**City of Albuquerque  
Stormwater, Erosion, and Sediment Control  
Construction Site Inspection Report**

ESC File #:	J15E053	Project Name:	Norbis Rehabilitation Hospital	
ABQ-PLAN #:	SWQ-2026-00007	Project Address:	1100 Woodward Pl. NE	
NPDES ID #:	NMR1007R6	Inspection Type:	Pre-Construction	
	<b>Owner</b>		<b>Contractor</b>	
Operator:	Albuquerque Rehab Real Estate Investors, LLC			
Contact Name:	Deno Maggi			
Contact e-mail:	<a href="mailto:Deno@crossdevelopment.net">Deno@crossdevelopment.net</a>			
Contact Phone:	375-871-8953			
<b>COA Inspector:</b>	<b>James Hughes</b>	<b>Date of Inspection:</b>	<b>4/1/2026</b>	<b>2:20pm</b>
NPDES Posting?	No	SWPPP?	No	Notice of Intent? Yes
Self-Inspection Reports?	No	Date of last report:	n/a	
Weather during inspection:	Rain	Estimated date of last storm 0.25" or greater:	1/8/2026	Snow
Temperature: ~	58	Construction Phase:	Mobilization	
Discharge off-site?	No	ROW:	Street

|                                  | <b>EROSION CONTROL PLAN</b><br><b>INITIAL SETUP</b>   | DATE<br>4-1-26         |

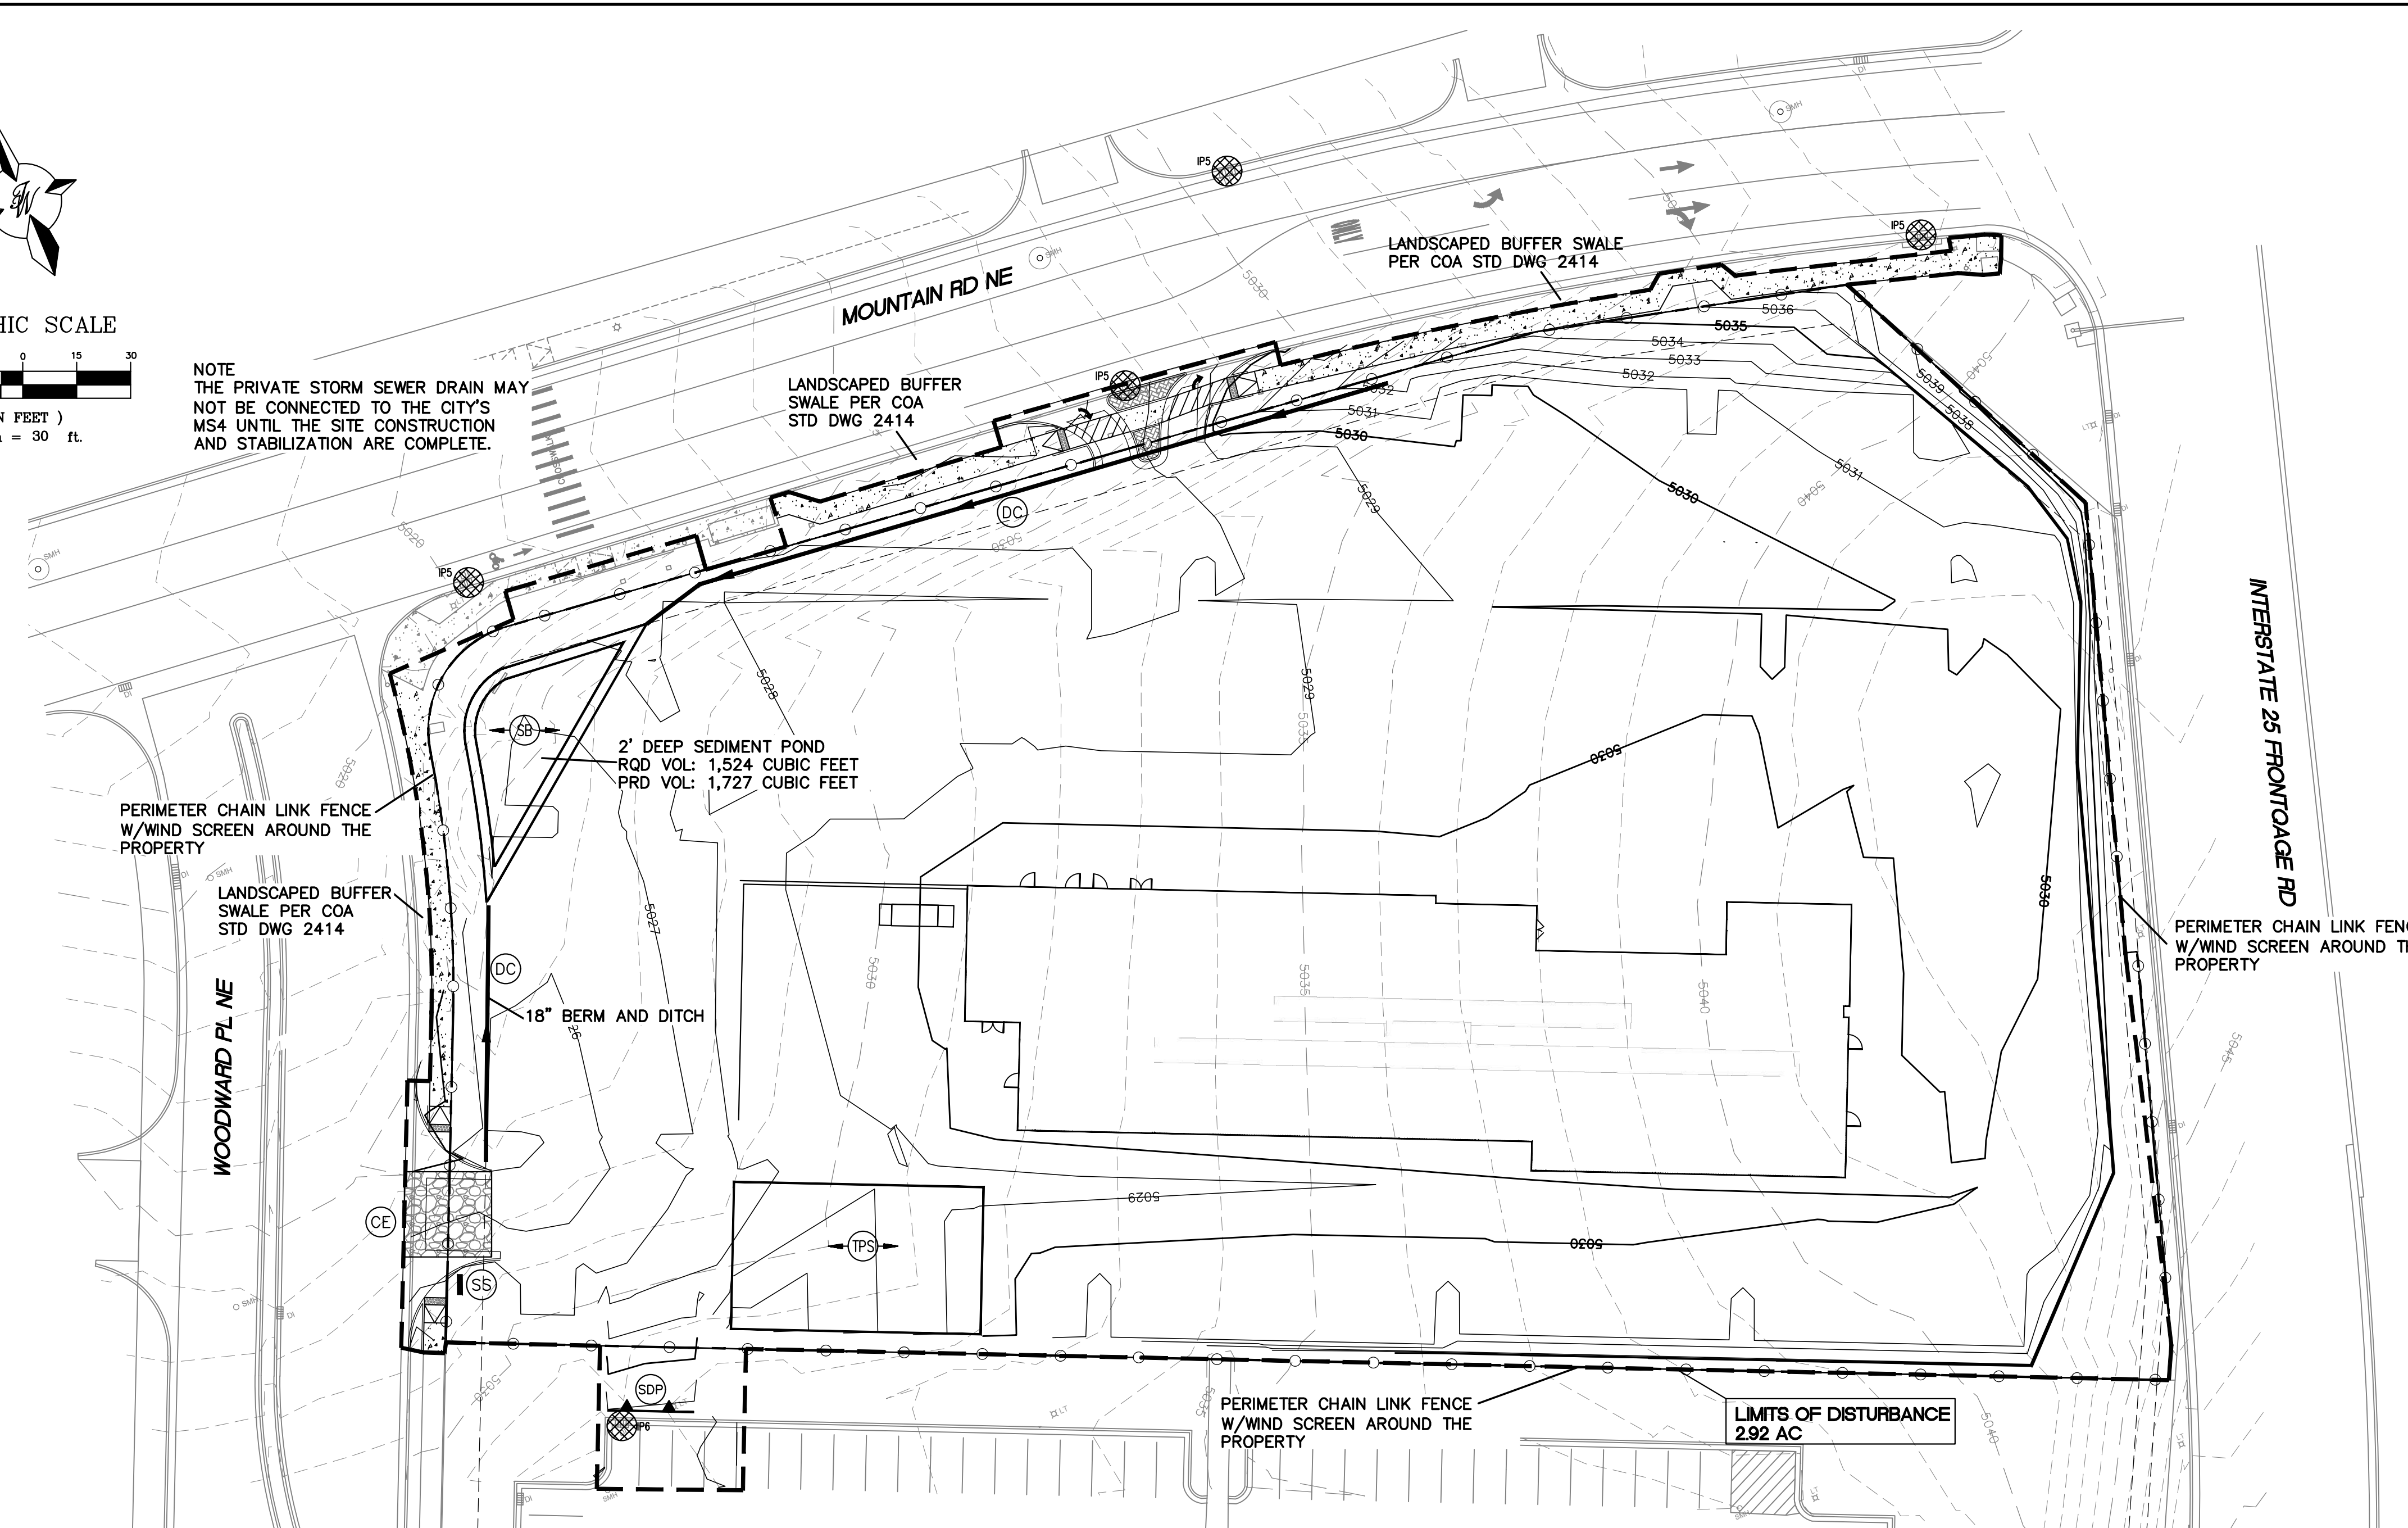
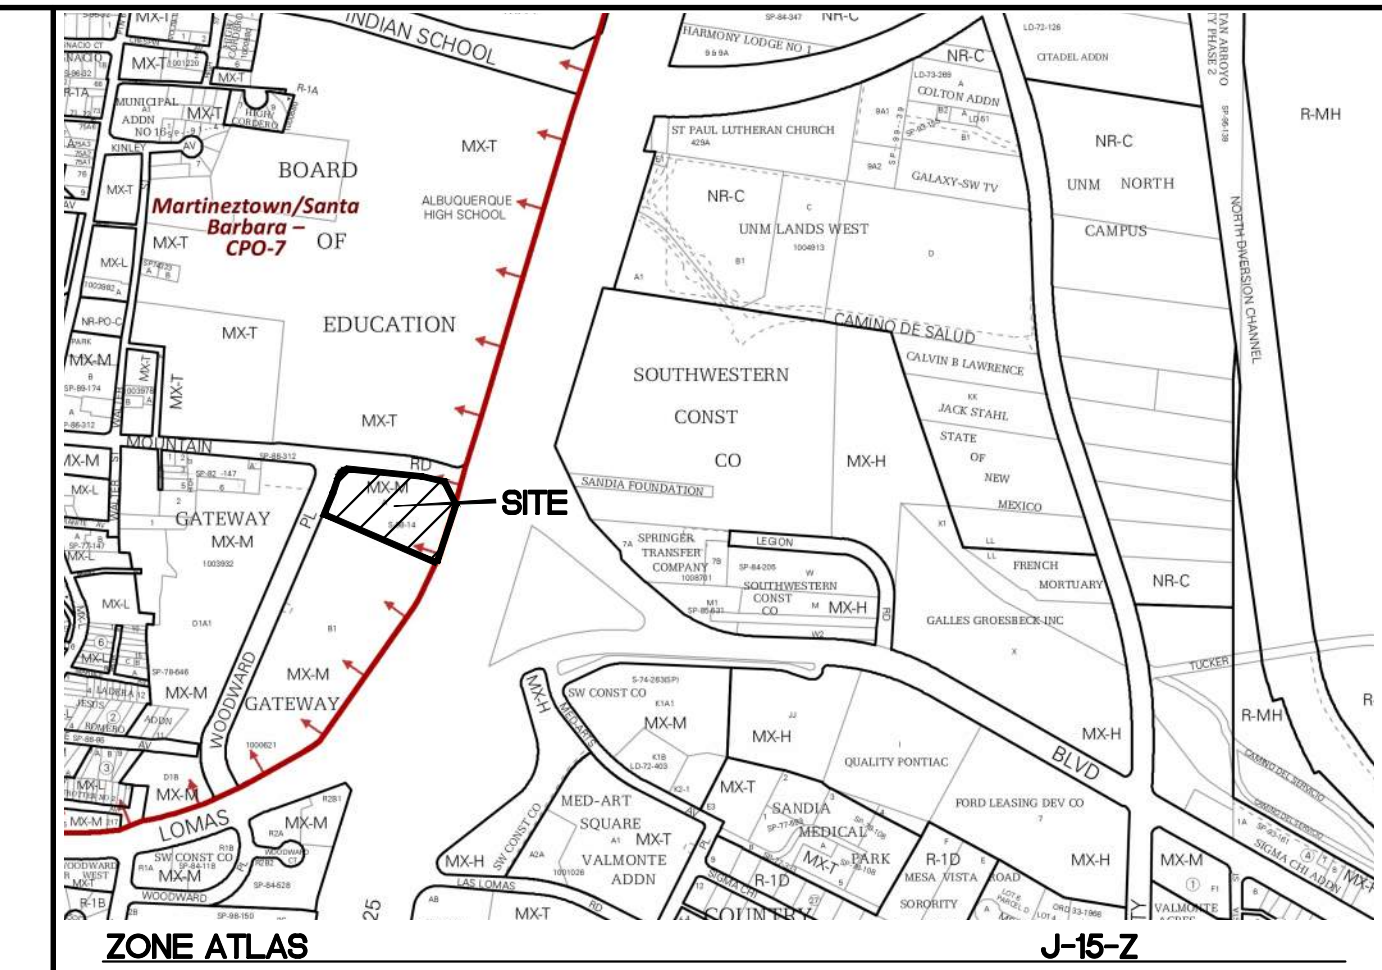
Item #	Violation Category	Deficiency/Corrective Action		
1	NOI	missing - Construction Support activity on the neighbor's property is missing from the ESC Plan and the neighbor's NOI is also missing. The ESC Plan shows a pavement connection to the neighbor's parking lot which doesn't require the neighbor's NOI since Albuquerque Rehab Real Estate Investors, LLC has an access easement, but the fenced area extends beyond that easement. The missing neighbor's NOI and inaccurate ESC Plan are violations of both the CGP and City Ordinance. <b>Required mitigation:</b> Either remove the Construction Support activities and stabilize any disturbed areas, or update the ESC Plan to show the construction support activities and provide the Neighbor's NOI.		
2	Porta-potty	Not supported and next to an inlet in violation of CGP 2.3.3.f. <b>Required mitigation:</b> Move the toilets away from the inlet and stake them down.
